Our Ref: LU/385/21/NMA

Non material amendment following the grant of LU/45/20/PL for the reconfiguration of fenestration to north and east elevations and omission of associated external amenity areas.
Saltmarsh House 1 Old Market Lane Littlehampton BN17 5FB

east elevation (section exiting)

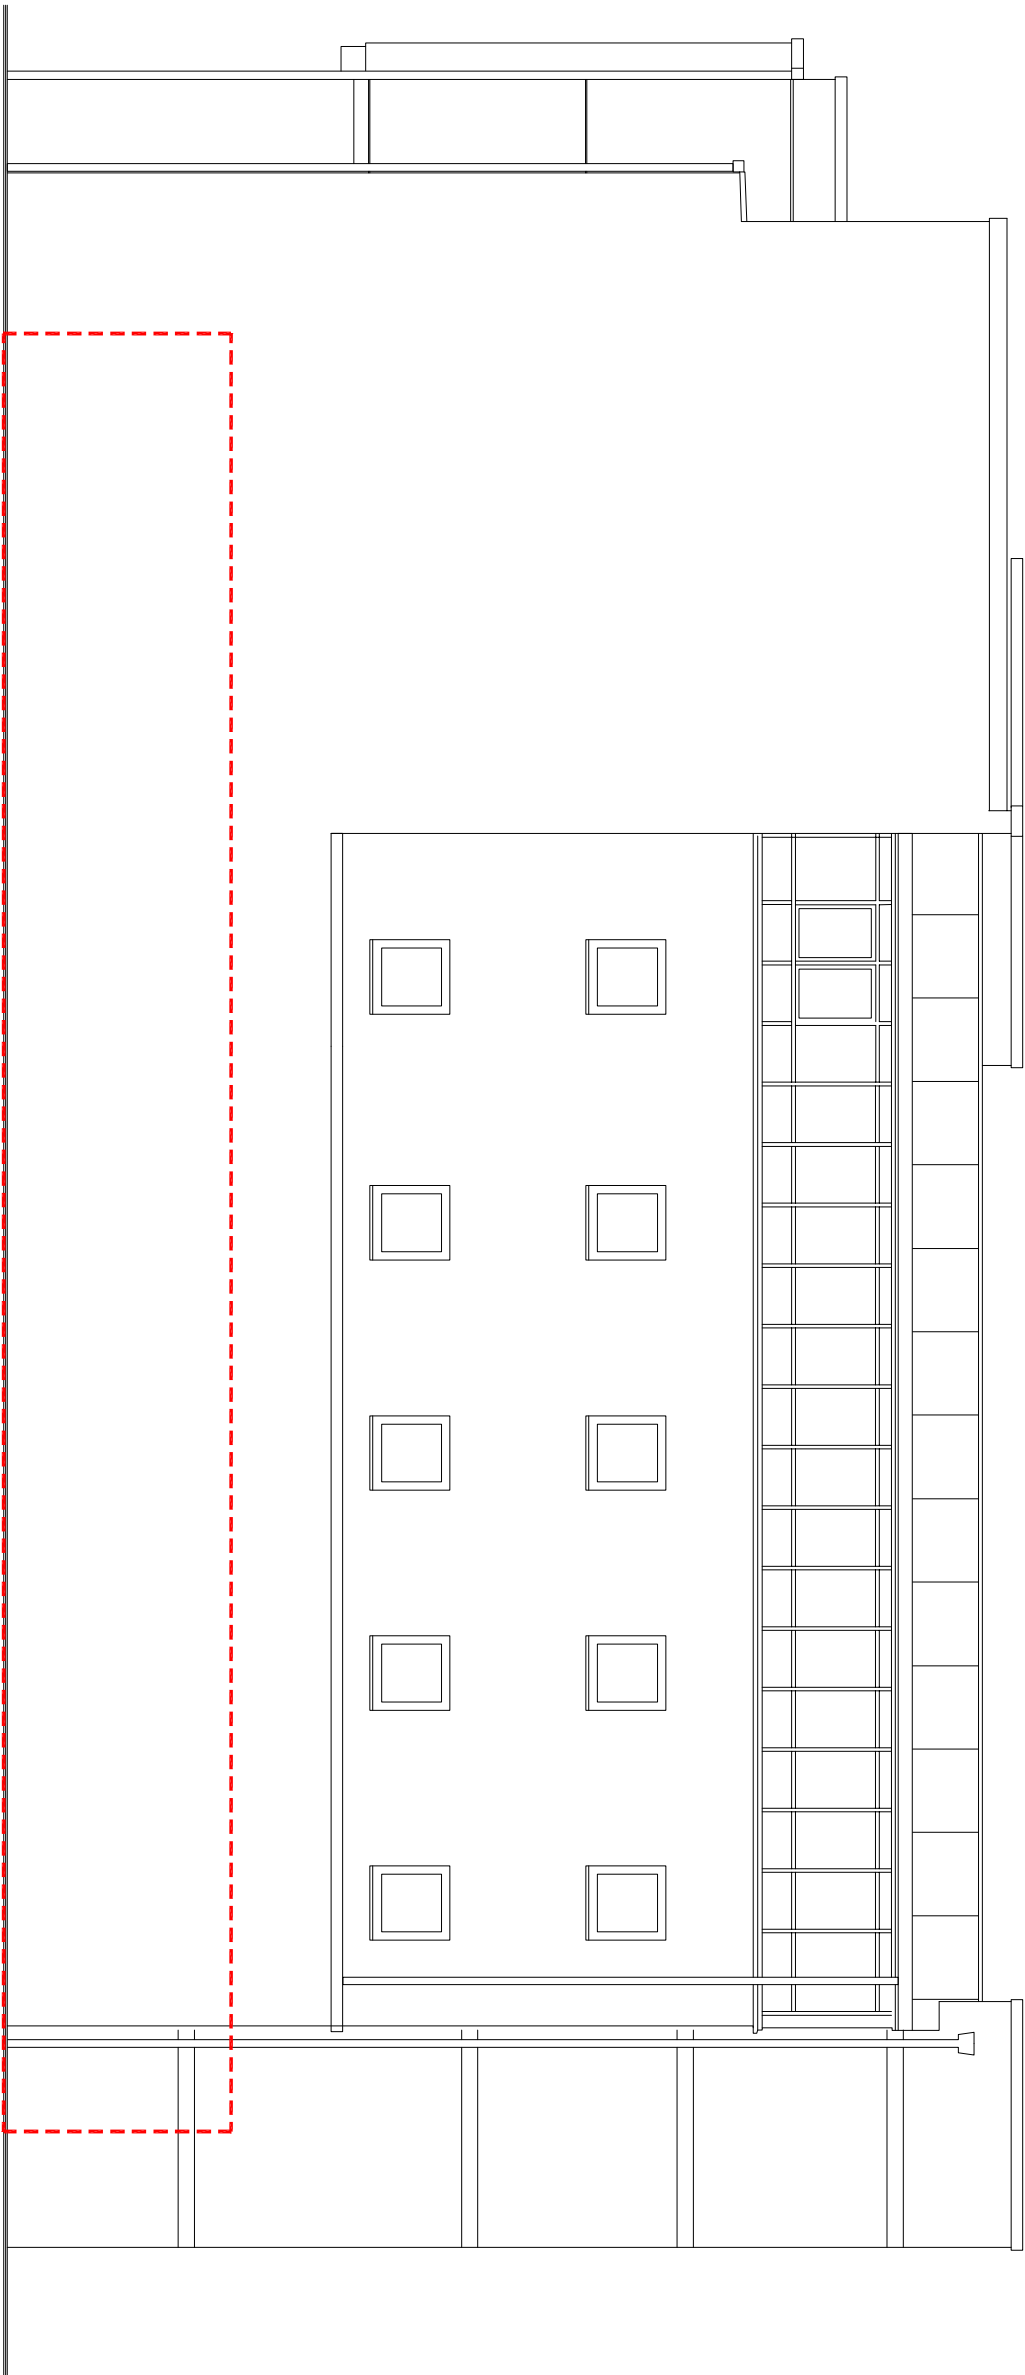
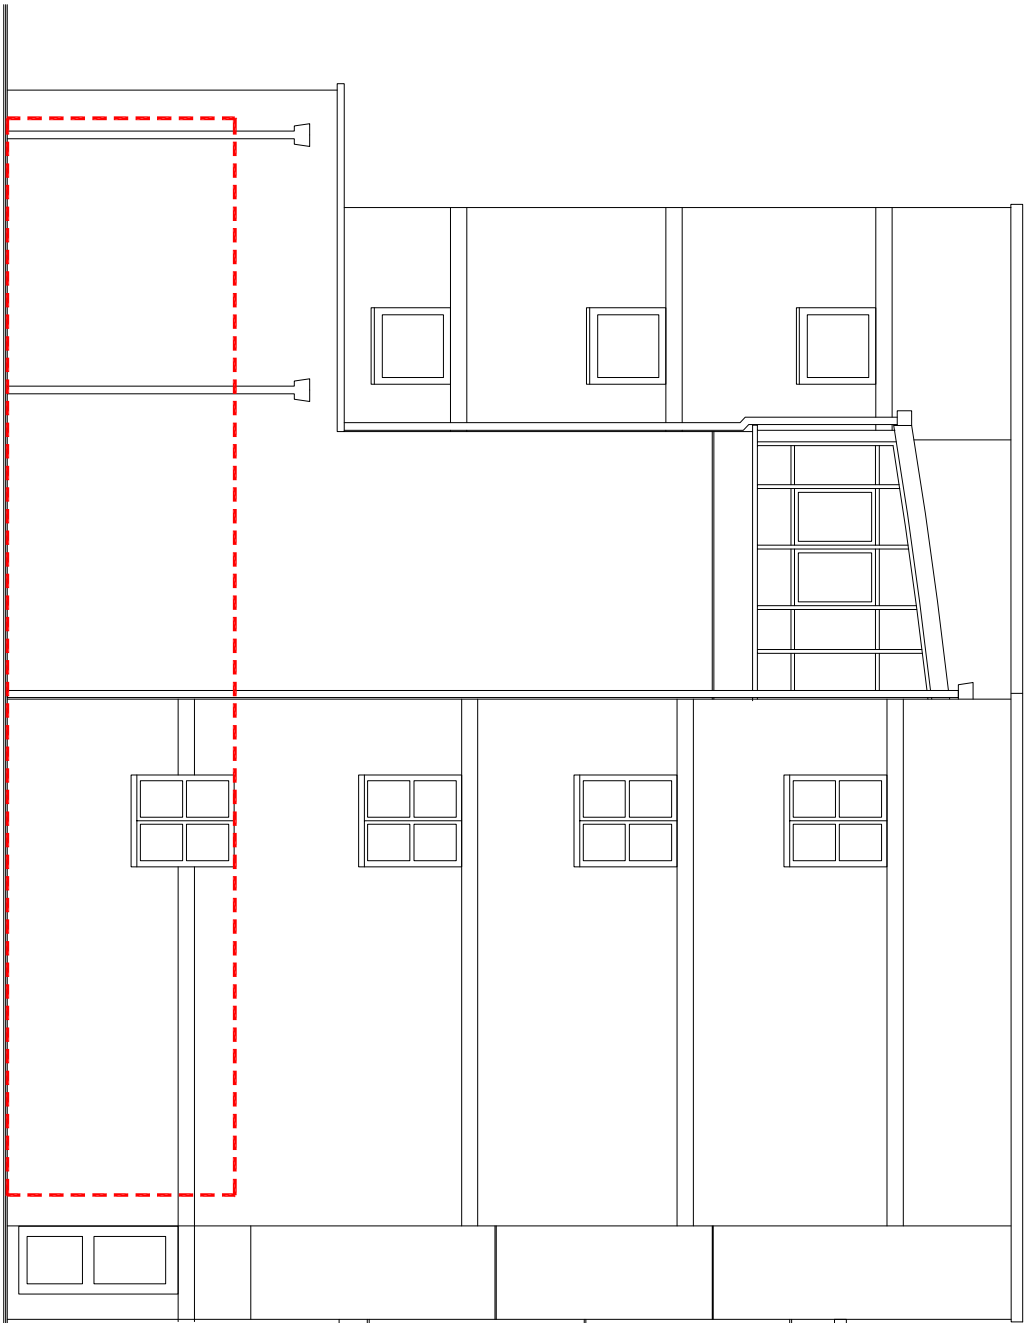
The proposed fenestration changes would not materially alter the visual appearance of the building nor result in any additional openings and thus no increase in overlooking and would therefore have no material impact on residential amenity.

However, the proposals would remove/omit all private external amenity areas serving the 3 flats. This would be contrary to adopted guidance in the Arun District Council Design Guide Supplementary Planning Document (2021) and would be considered a material change to the approved scheme, since it would result in the flats not having access to any private external amenity space.

The proposed fenestration changes can be considered to be NMAs, however the change in

respect of the omission of the external amenity areas is not considered to be a NMA under section 96A of the Town and Country Planning Act 1990, and the NMA application can therefore not be granted.

Instead this change would have to be considered under a Section 73 variation of condition application to vary condition 2 (approved plans) of LU/45/21/PL and its acceptability would be assessed under said application.
